Cameron Pines

Re: Status of Improvement Permit Application # 08-5- 21231 – Lt 3

PRELIMINARY SITE PLAN FOR:  
**WYNN CONSTRUCTION**  
 PIN 9587-53-8481.000  
 PARCEL ID 039586 0024 41  
 LOT 3 CAMERON PINES S/D  
 PB2007 PG1002  
 10/29/08  
 1"=40'  
 105 CAMERON PINES DRIVE  
 SANFORD, NC 27330

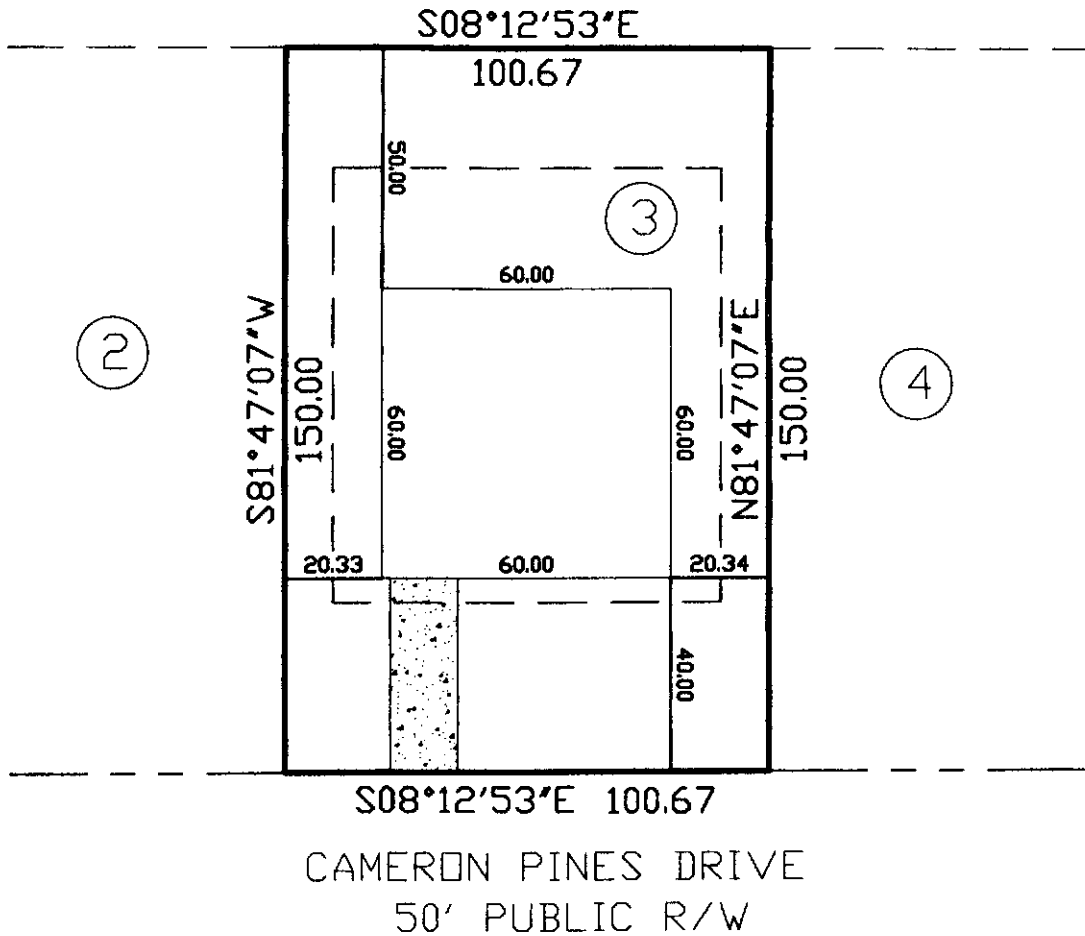
- _____ 1. Property lines/corners not marked or labeled *(\$25.00 fee incurred)*
- _____ 2. House corners not marked or labeled *(\$25.00 fee incurred)*
- _____ 3. Directions not clear to property *(\$25.00 fee incurred)*
- _____ 4. Property needs brush or vegetation removed
- _____ 5. Backhoe pits required
- X 6. Other – Move house as shown. You must reduce house footprint to meet setbacks shown and change drive as shown also.**
